I write as Chairman of Burbage Parish Council. Below is a mixture of comments I was hoping to make at the ISH6 hearing, and comments which follow on from the evidence heard at ISH6 itself. It was unfortunate that time constraints at the hearing prevented concerns of Burbage residents being heard in person.

Assessment of the Impact of Motorway Closures

Monitoring HGV Movements

Figure 4: Prohibited and Key Advisory HGV Routes

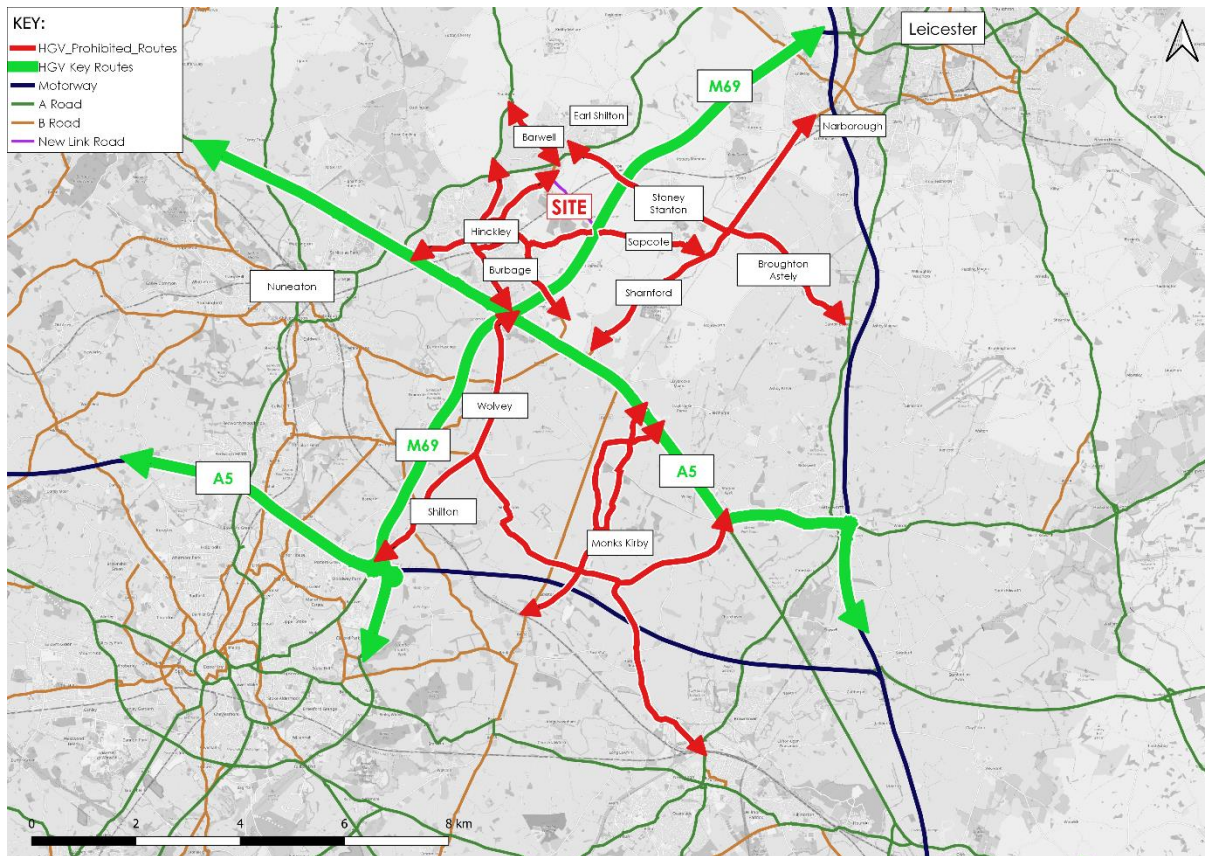
We are concerned that a very likely route from the proposed development is to Magna Park on the A5. It is clear that the 'normal' route would be via the M69 to the A5 at junction 1. However, any minor congestion at the M69 Junction 1/A5 could encourage a route through Burbage taking the B4669 West to Burbage, turning through the village on the B578 and joining the A5 to the East of the M69/A5 junction. This route has no current or proposed weight restrictions for HGVs and only discouraged with the label 'Prohibited route'.

The management of 'Prohibited Routes' being;

- An information campaign, to **'avoid these routes'**
- Leaflets **'to guide'** drivers
- Regular engagement

Figure 6: Proposed ANPR Camera Locations

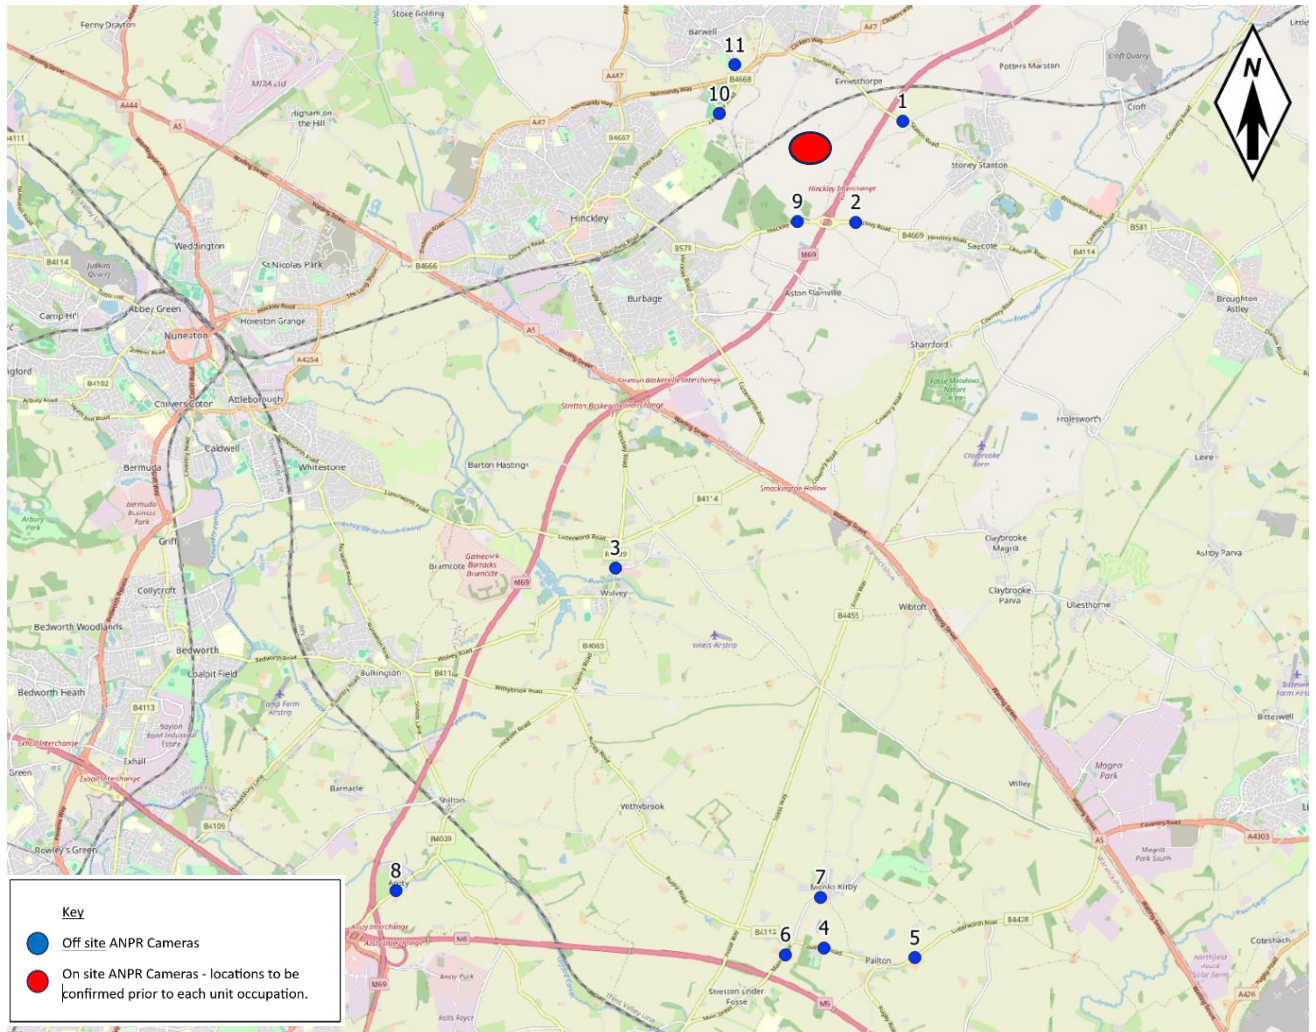
The monitoring of the routes being undertaken is predicated entirely on 'normal' traffic conditions whereby monitoring cameras are proposed understandably in Sapcote, but also in relatively distant villages of Pailton, Wolvey and Monks Kirby where 'normal' modelling has flagged sensitivity.

We are strongly of the opinion that HGV enforcement cameras are additionally essential to monitor traffic leaving the site west bound on the B4669 Sapcote Road, such camera will protect all routes accessed from this direction.
